East Anglia ONE North and East Anglia TWO Offshore Windfarms

Applicants' Comments on Suffolk Preservation Society's Deadline 5 Submission

Document Reference: ExA.AS-20.D6.V1

Date: 24th February 2021

**Viewpoint 5 Public Rights of Way, near  
Moor Farm (with National Grid GIS  
Substation)**

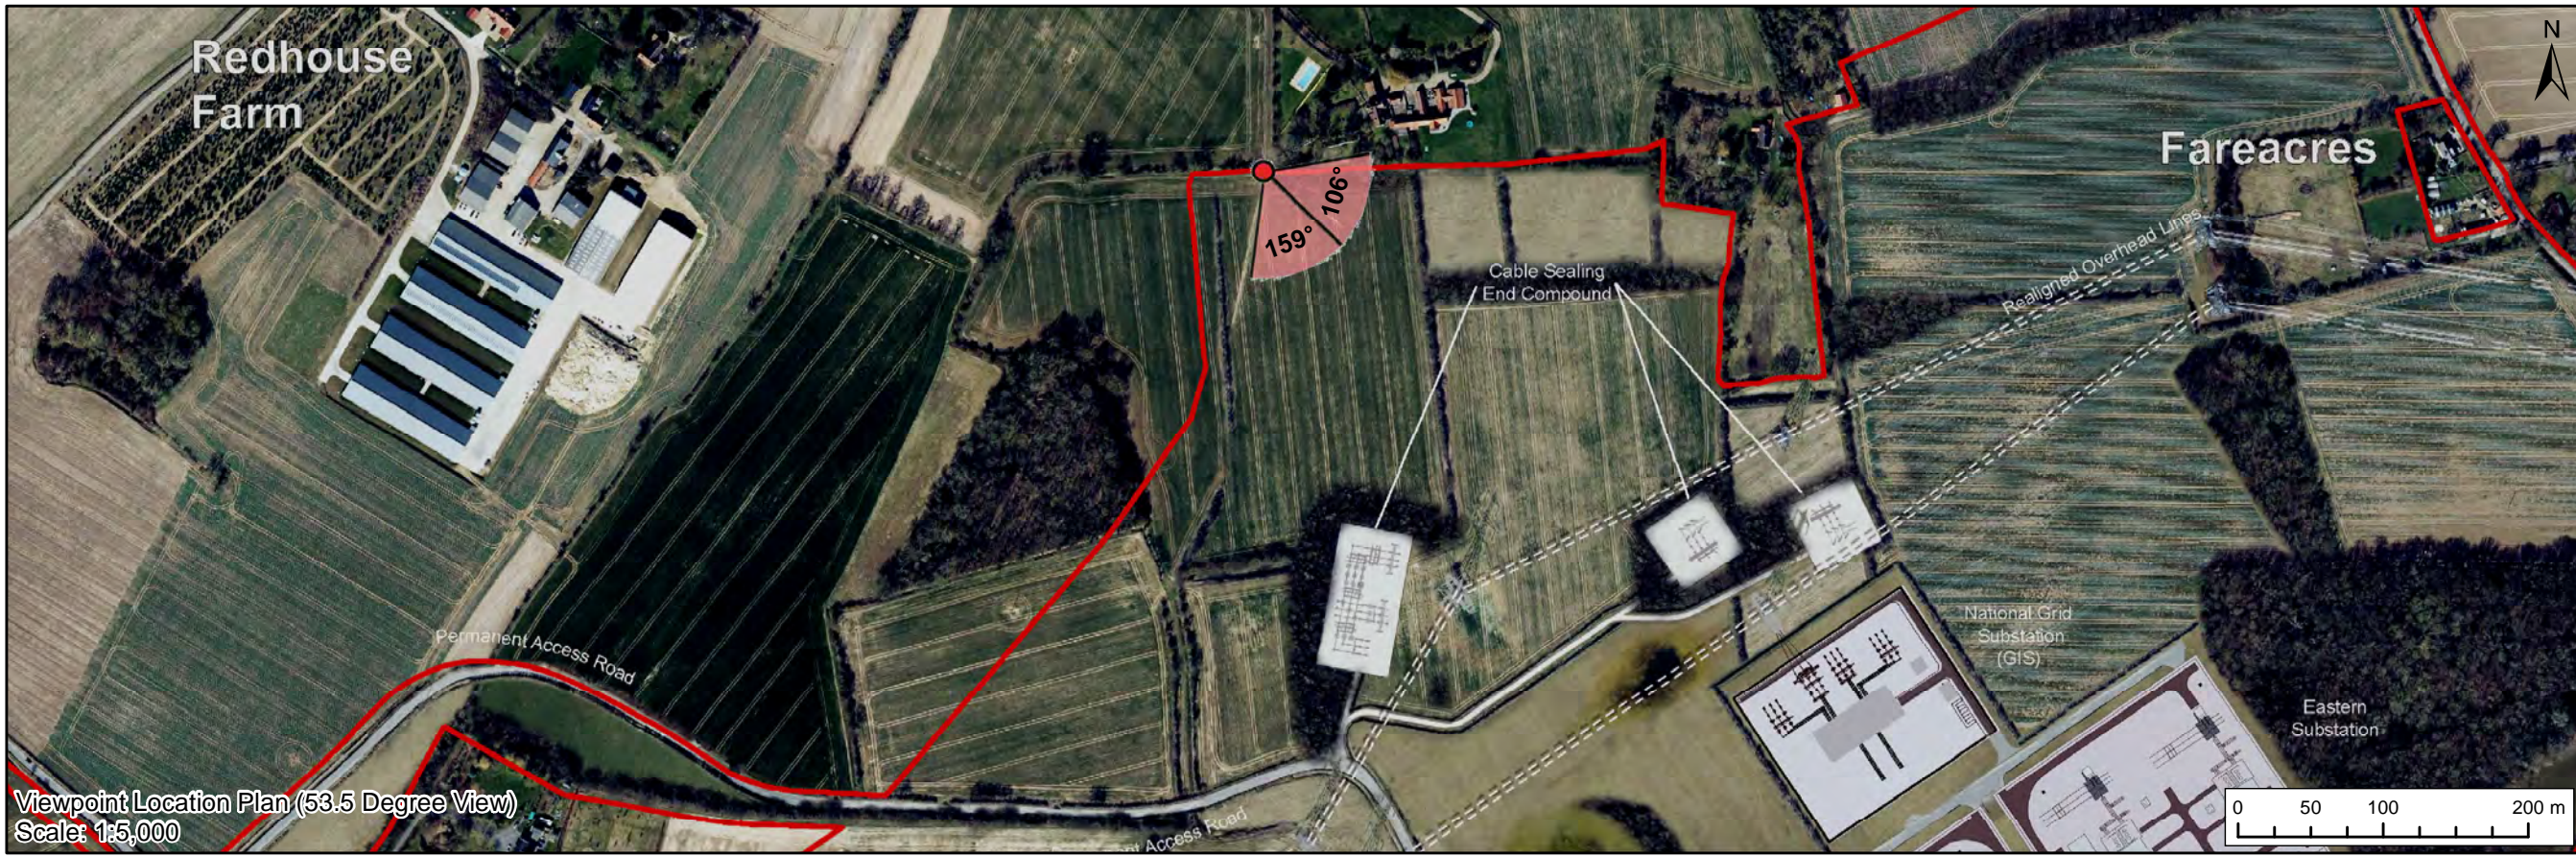
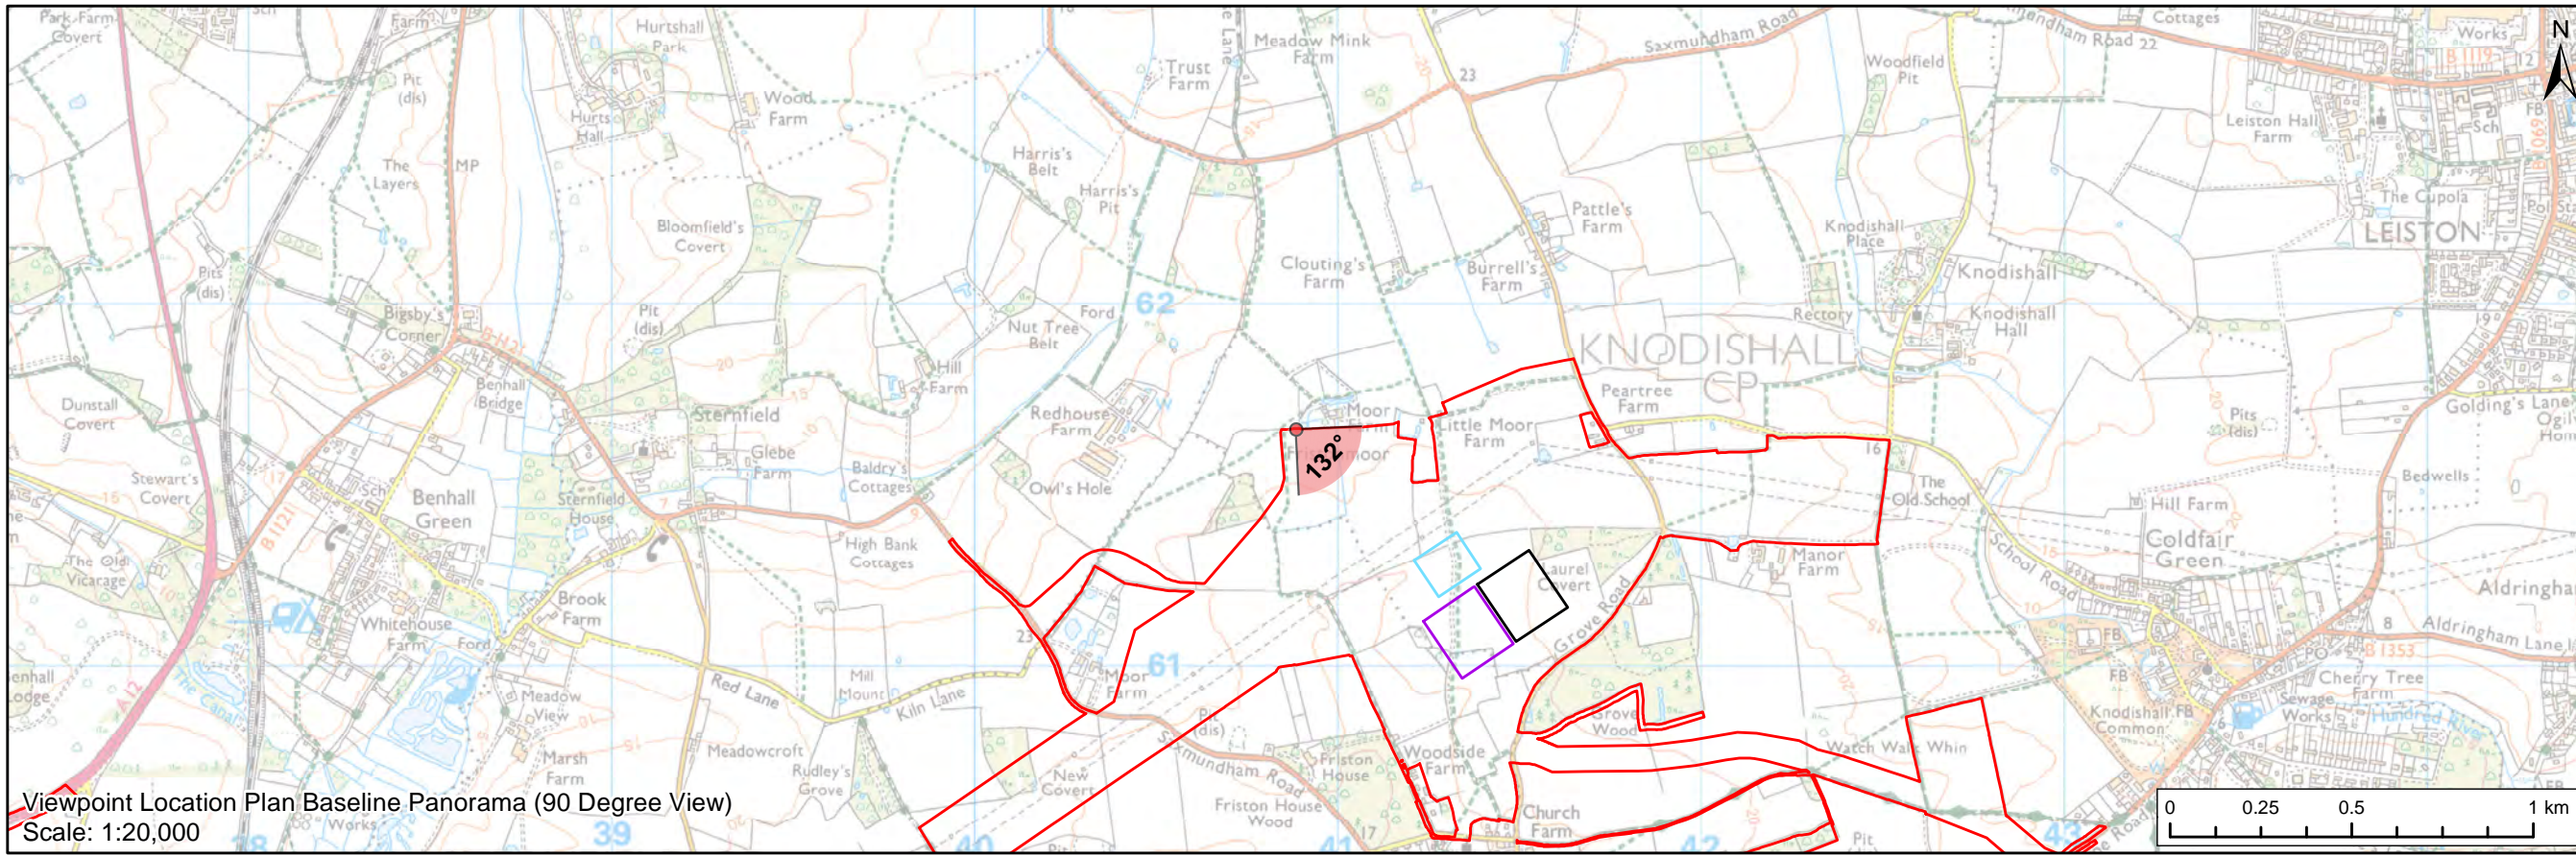
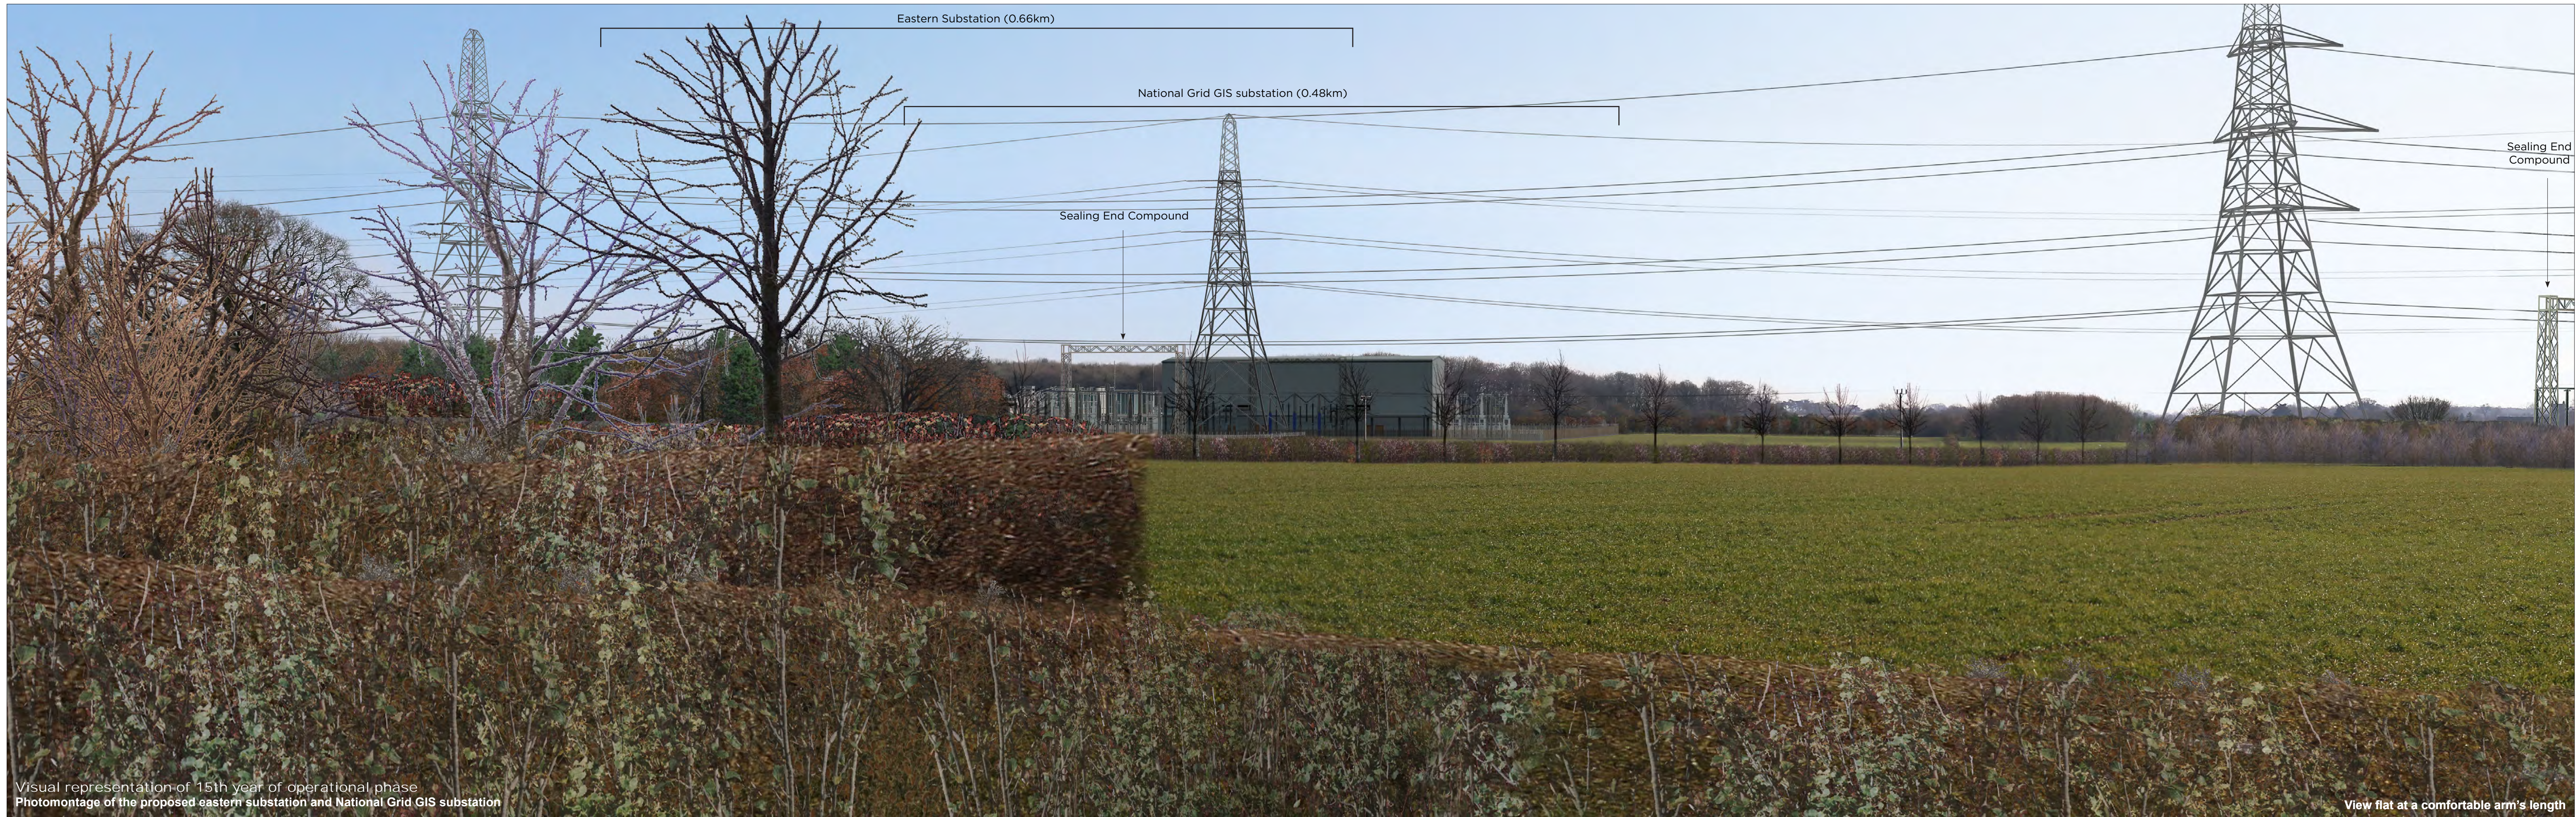
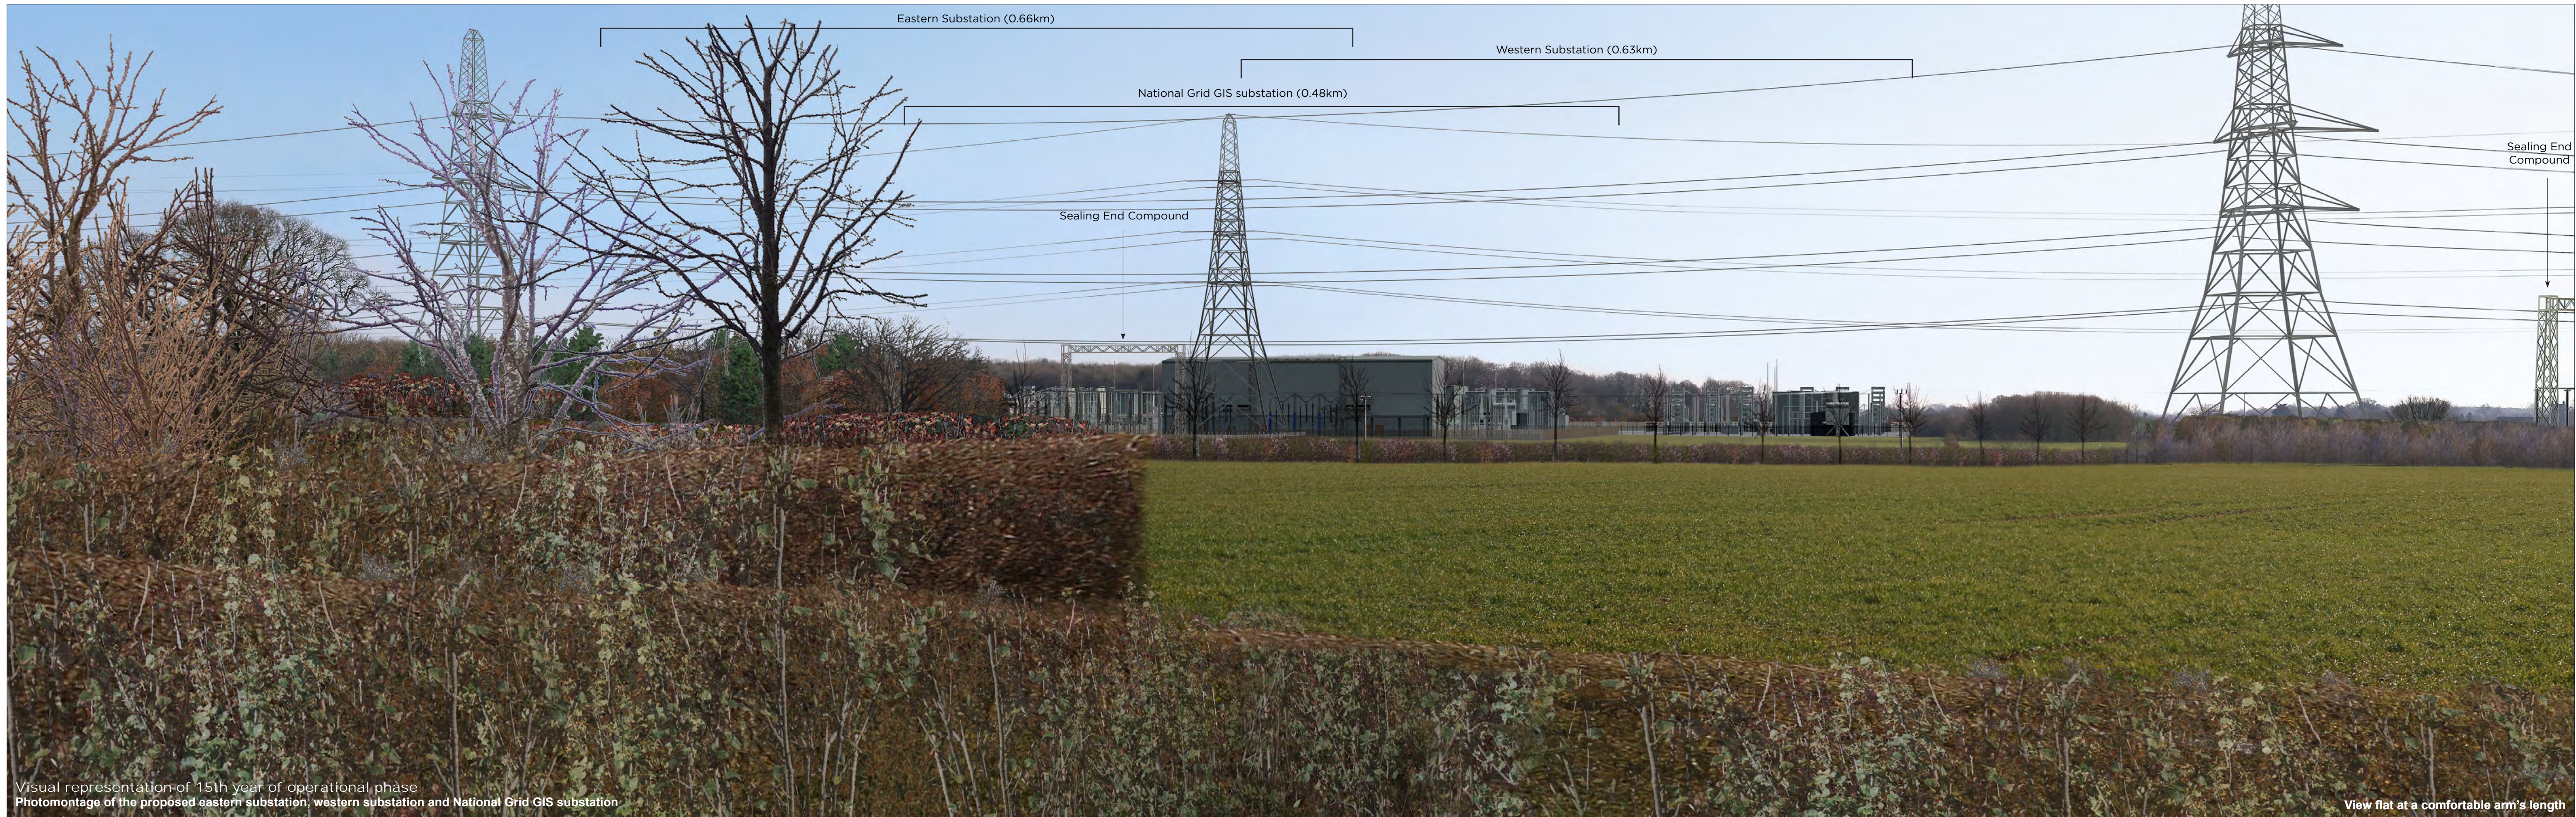
ID	Written Representation	Applicants' Comments
9	<p>Landscape Viewpoint 5 - The visualisation effectively demonstrates that the views over the wider landscape and in particular towards St Mary's Church, will be lost. The landscaping proposed merely exacerbates the loss of this visual, historical and cultural link. Despite the reduction in height of some of the structures the gantries of the National Grid and Western substation remain highly prominent in the landscape.</p>	<p>The Applicants note the visual effects shown in LVIA VP 5 and the presence of the substation infrastructure in the view towards St Mary's Church. The Applicants would note that the openness of the wider view over the landscape would be retained, even in the presence of the substation infrastructure. The landscape proposals will reduce the visual impact of the substation infrastructure. Re-instated hedgerows and tree lines will contribute towards a network of re-instated historic field boundaries which have been lost to agricultural intensification over the years.</p>
